# CITY OF PORTLAND BUILDING PERMIT

PERMIT ID: 2012-50599

has permission to **Change of use to add dance & concert venue - install new fire door/landing & stairs** provided that the person or persons, firm or corporation accepting this permit shall comply with all of the provisions of the Statutes of Maine and of the Ordinances of the City of Portland regulating the construction, maintenance and use of the buildings and structures, and of the application on file in the department.

**Jeanie Bourke - RE: 250 Read St. plan review comments BP#2012-50599**

Door Exterior
Landing
Pg 3 of 7

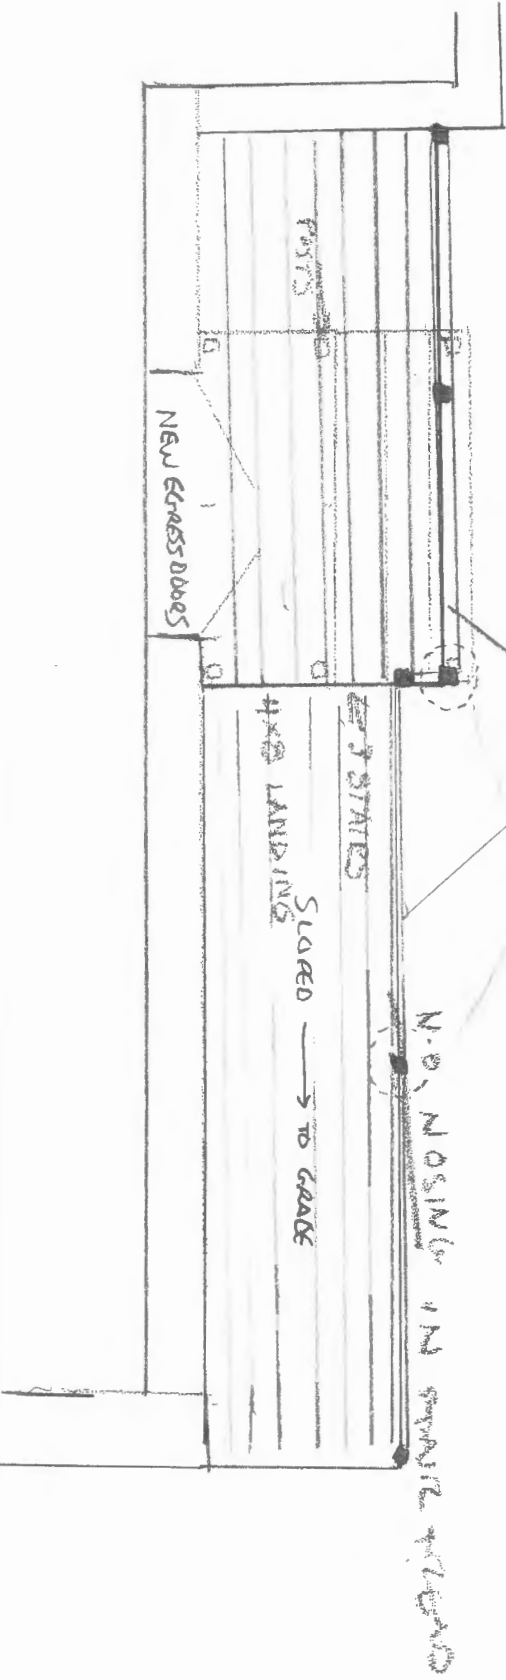
1. Clarify that a permit will be applied for at SFM, not just license app
2. Provide a concert seating diagram to scale or with aisle & spacing dimensions
3. Provide a layout or intention for the game room to justify the net 15 occupant load
4. Provide the area of the media room with calc for Business at 100 gross occ. Load
5. Provide a diagonal of the bldg. and the distance between the 2 egress doors
6. Provide life safety device location on plans
7. Confirm panic hardware to be installed on new door
8. Provide section of new ext. platform and steps with frost protection, attachments, bearing, stair profile & dimensions, and graspable handrail

8. Fred or the engineer will provide the details on the exterior stair and landing, which are also required by the SFM. Still awaiting these details.

- 7) Elevation change between the inside and outside of the new exit door shall not exceed 1/2 inch.
- 8) Access to the stage shall be approved stairs or ramps with handrails in accordance with NFPA 101:12.2.

- 14) Notice: The first scheduled final inspection fee is at no charge. Additional inspections shall be billed at \$75 for each inspector.
- 15) Guards are required for the landings and stairs if they exceed 30 inches above the adjacent finished ground level.
